Berry, Huff, McDonald, Milligan Inc.
Engineers, Surveyors

March 11, 2014

RE: Level I-Minor Residential Development Review Site Plan Revisions
Single Family Lot
218 Washington Avenue
Tax Map 10, Block A, Lot 15

These revisions are based on comments from your office dated February 10, 2014. The following is our response to these comments using the same numbering system for clarity:

**DETAILS**  
**PROPOSED LOT**  
218 WASHINGTON AVENUE

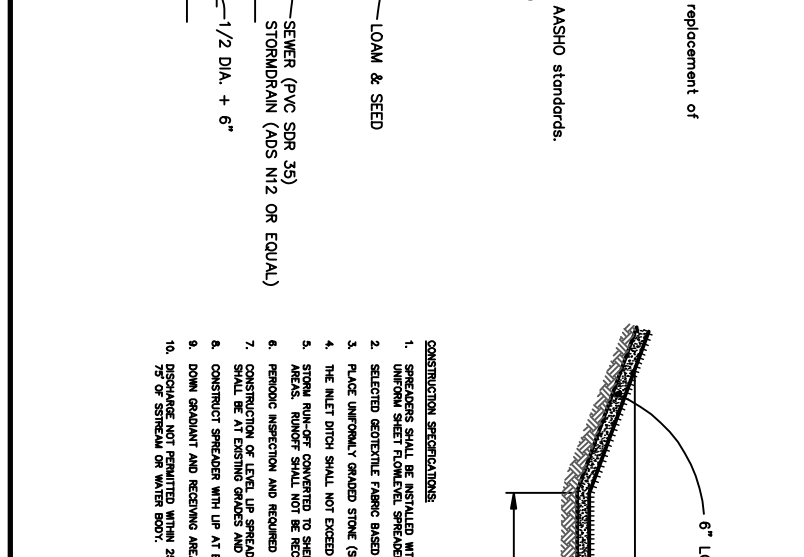
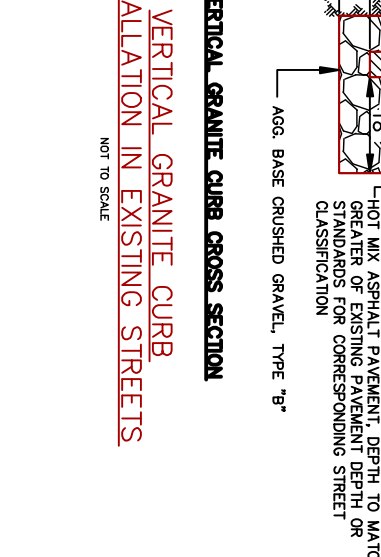
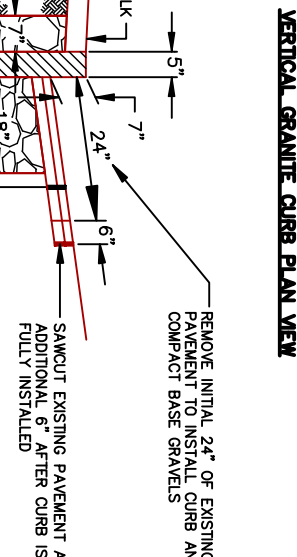
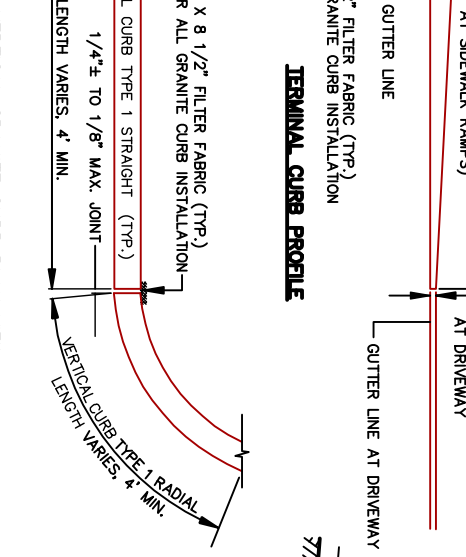
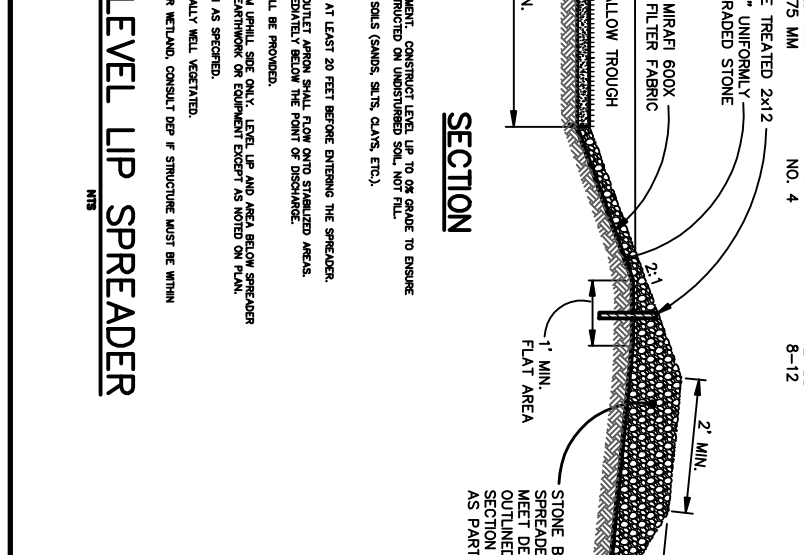
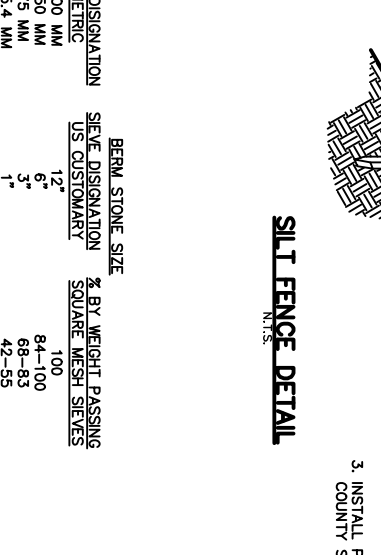
- The plans have been revised to show a plunge pool at the outlet of the roof drip edge on the Southern portions of the site. A detail sheet has also been created that shows all pertinent site details including the roof drip edge and the plunge pool. No adverse impacts will be created to the abutting lots or downstream conditions as a result of the development of this lot.

- Granite curb tip downs have been added to the plans as requested. A detail has also been added to the plans (see sheet 2).
 - The requested note was added to the plans regarding work within the Washington Avenue right of way
